Helios Renewable Energy Project

The Applicant's Responses to Deadline 5 Submissions

Planning Inspectorate Reference: EN010140

Table 3.1 – Landscape Mitigation Proposals [REP5-017]

**Environmental Statement Figure 7.13.1:
Cumulative ZTV, Proposed Development
and Solar Farm on Land South of A645 –
Bare Earth**

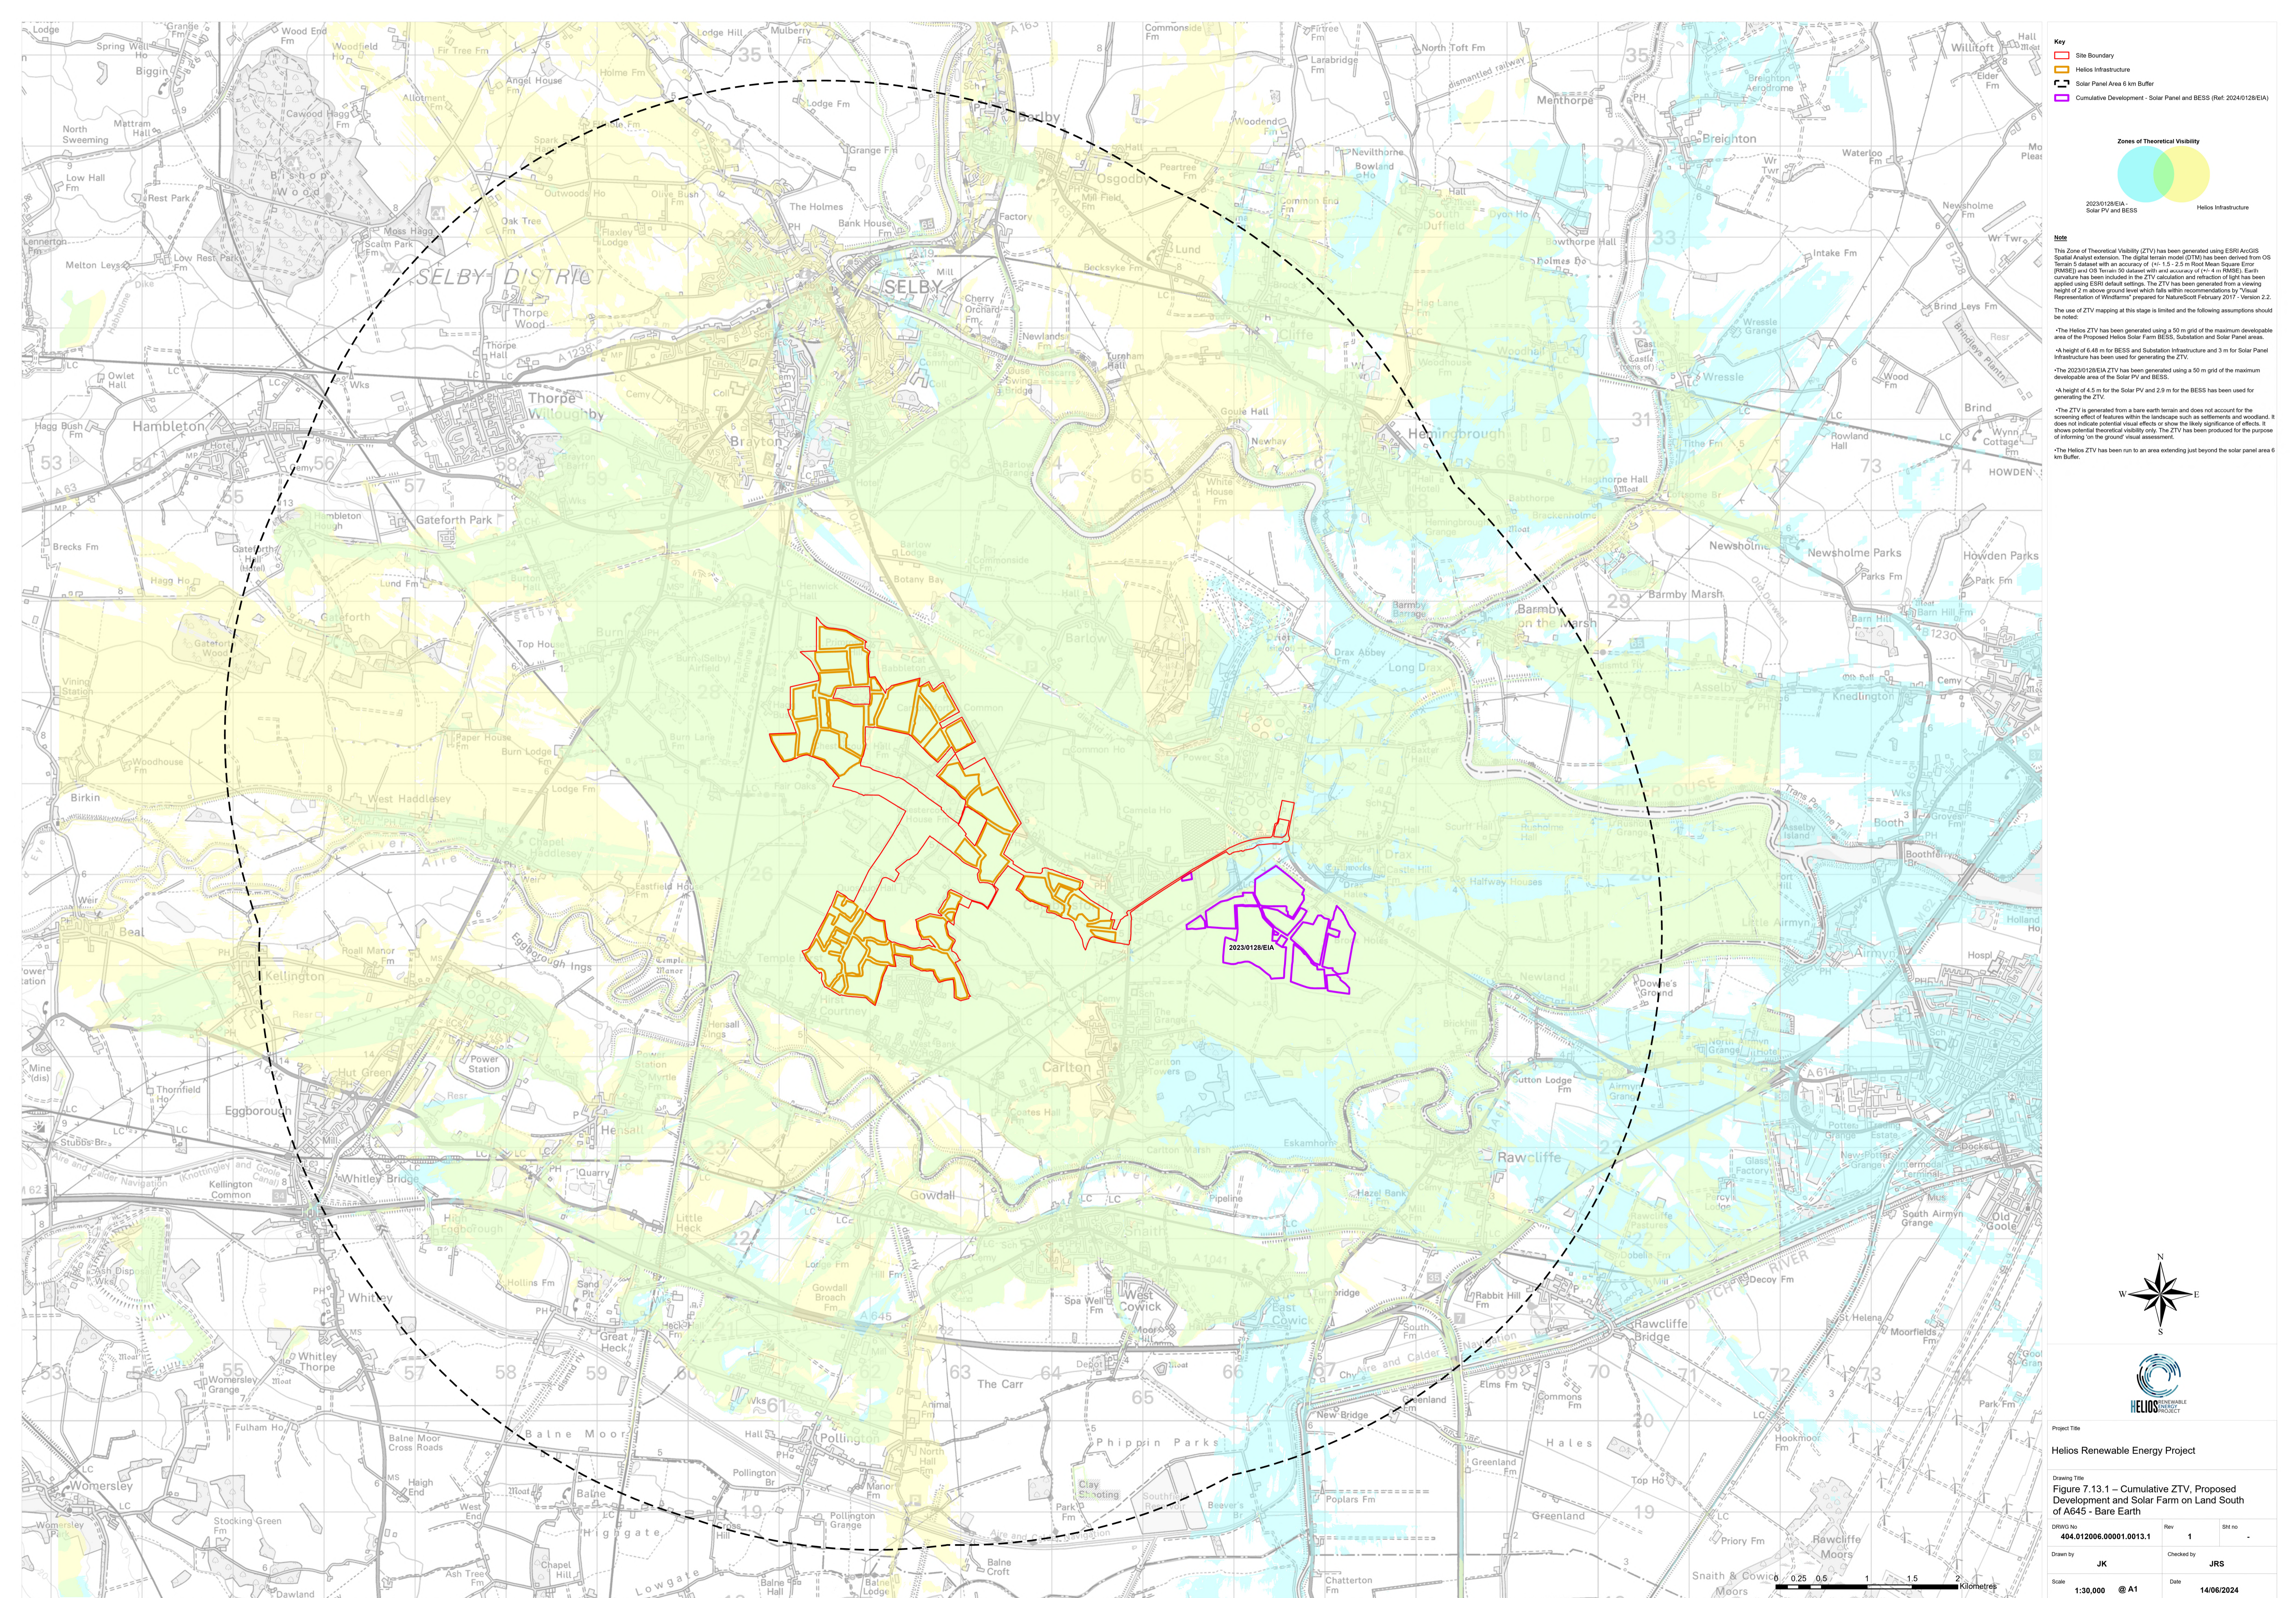
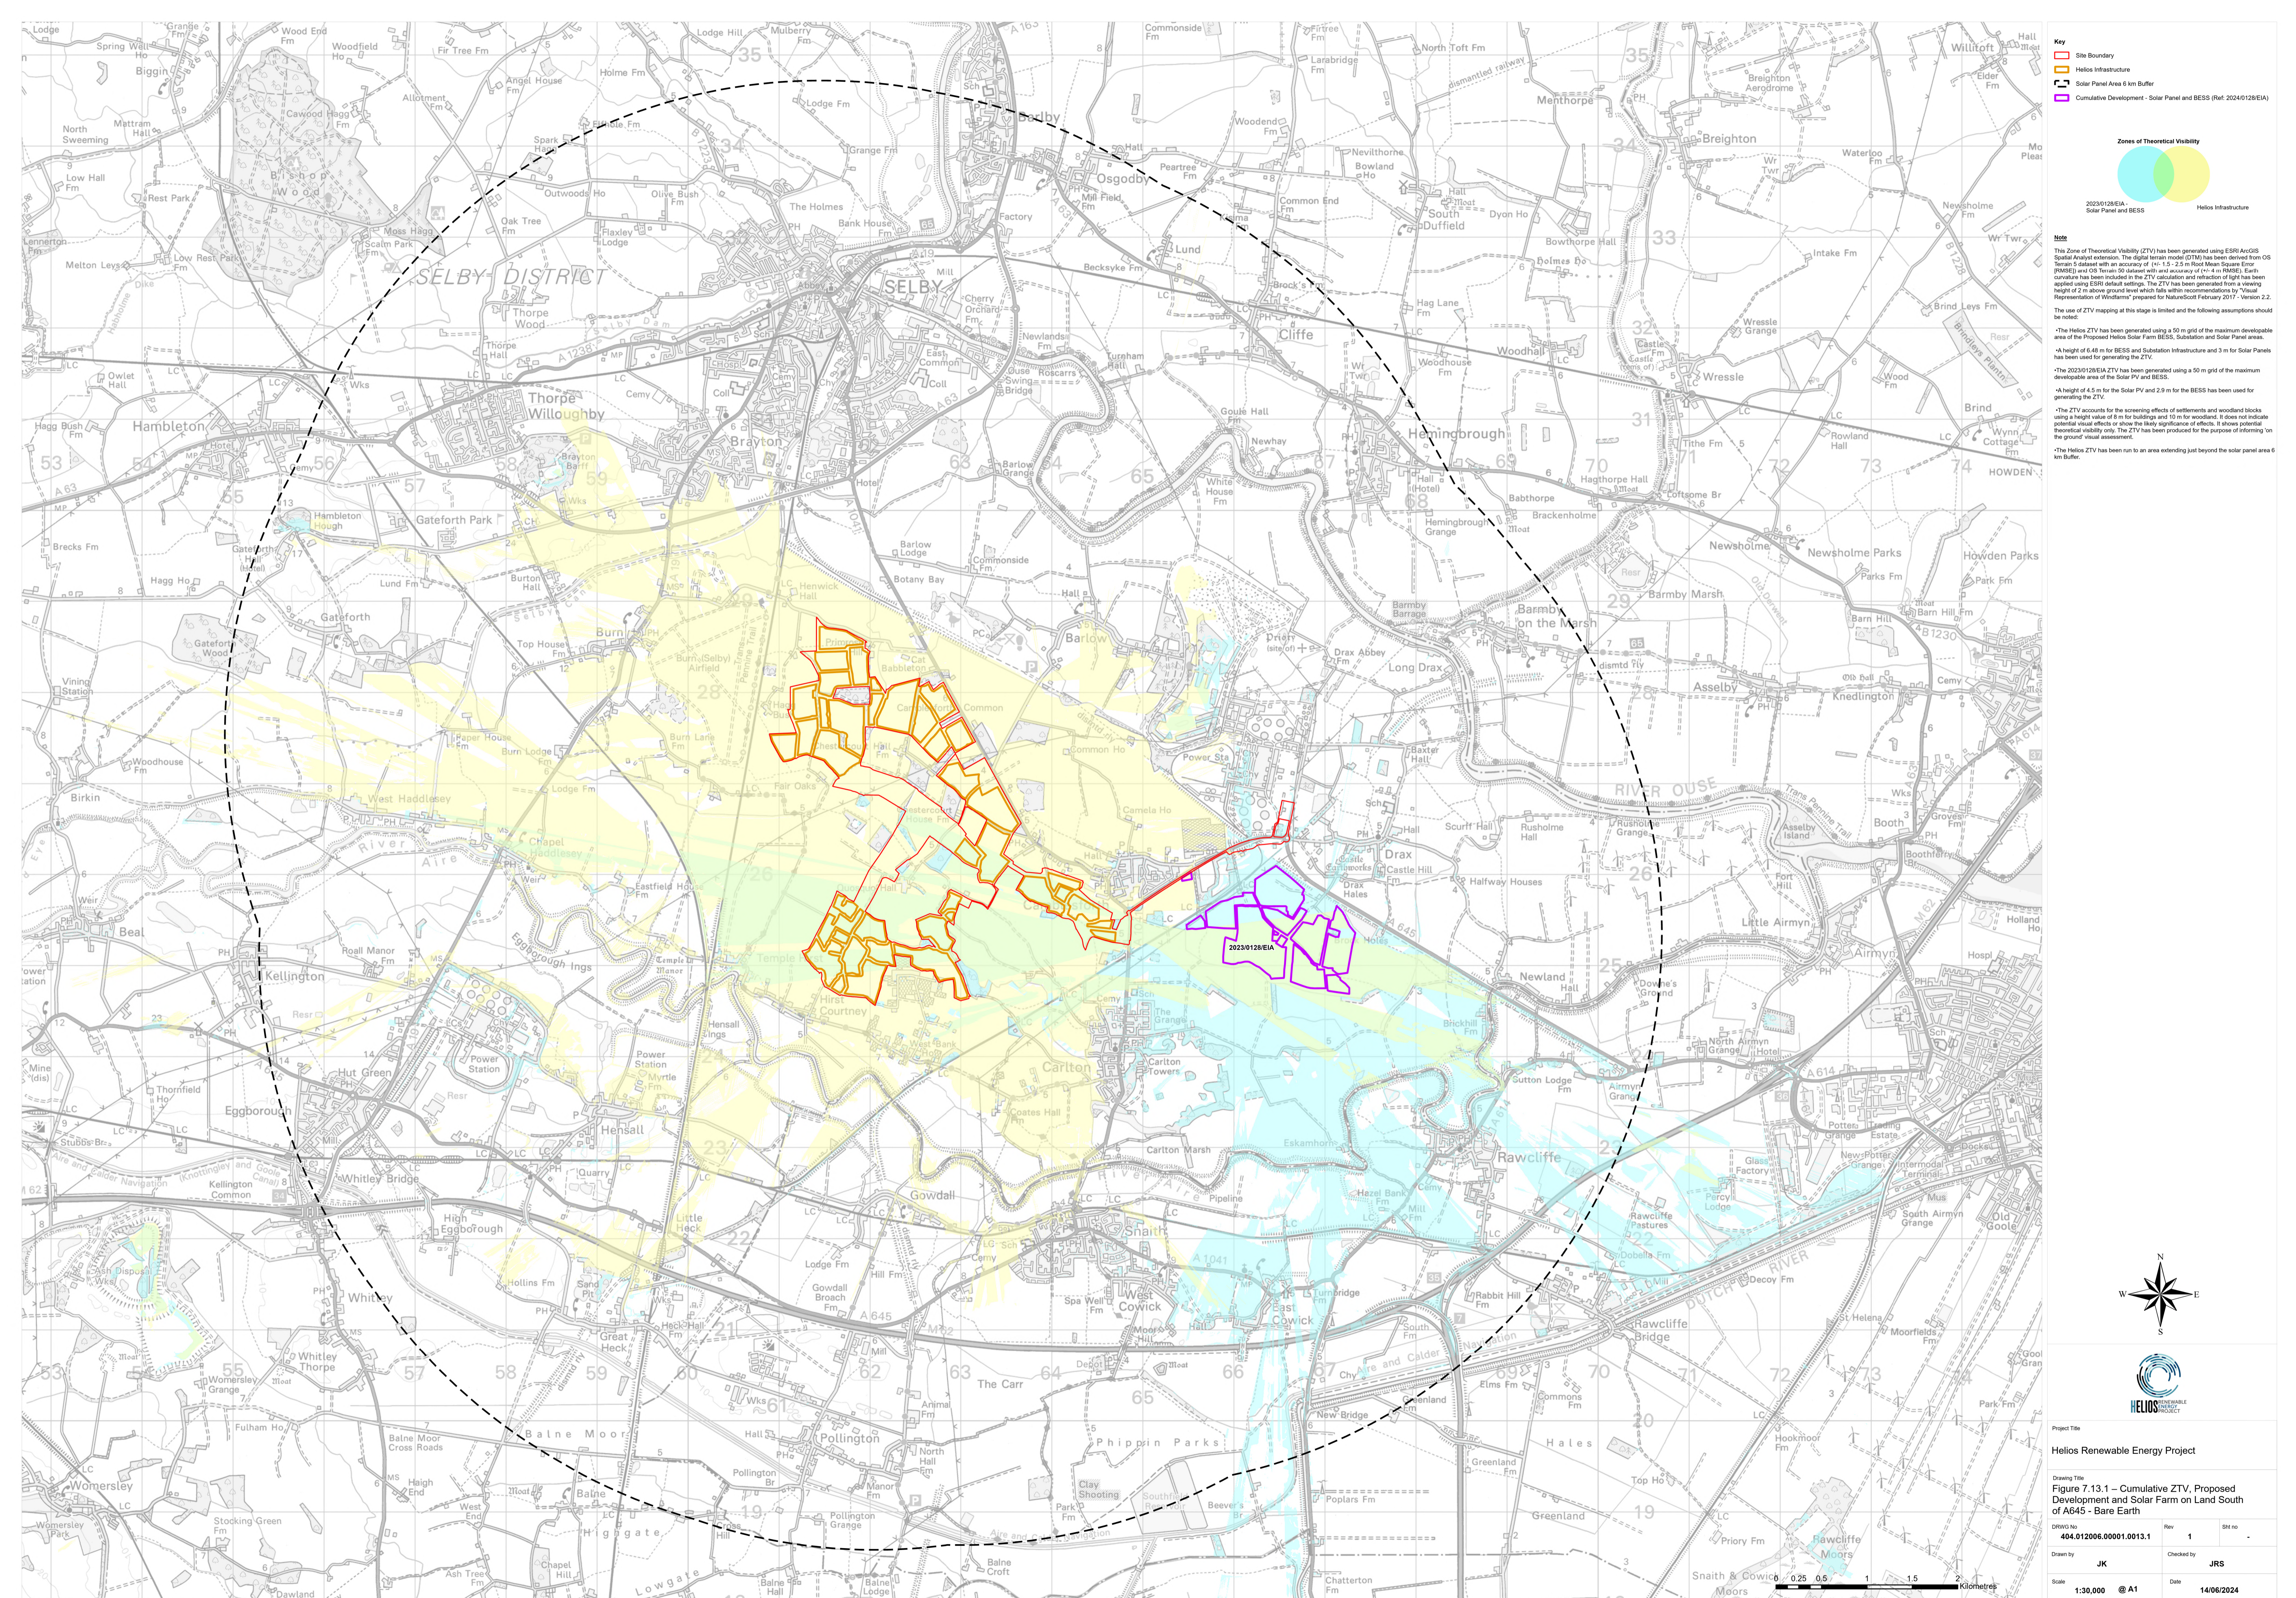
3.5	<p>In considering cumulative effects several major schemes have been scoped out of the assessment without good reason on the basis that cumulative scheme is located 2.5km from the main part of the Site and no significant effects were recorded in the LVIA for the site [for example, App-027 Landscape and Views – cumulative Scheme ID CS8, page 167]. Scheme CS8 is within the agreed Study Area. We would expect the cumulative assessment to consider all impacts collectively. Where significant cumulative effects are already identified relating to several schemes within the same landscape character area (LCA 15 - Camblesforth Farmland), we would expect other impacts to further add to this impact (rather than not being considered).</p>	<p>Cumulative effects are set out in Section 7.8 of the LVIA [APP-027].</p> <p>The LVIA states that the operational phase of the Proposed Development would result in significant cumulative landscape effects in relation to Camblesforth Farmland (para 7.8.17 and 7.8.18). This is due to relationship between this Proposed Development and other developments, notably Solar Farm south of A645 Wade House Lane and Solar Farm on land north and South of Camela Lane, Camblesforth.</p>
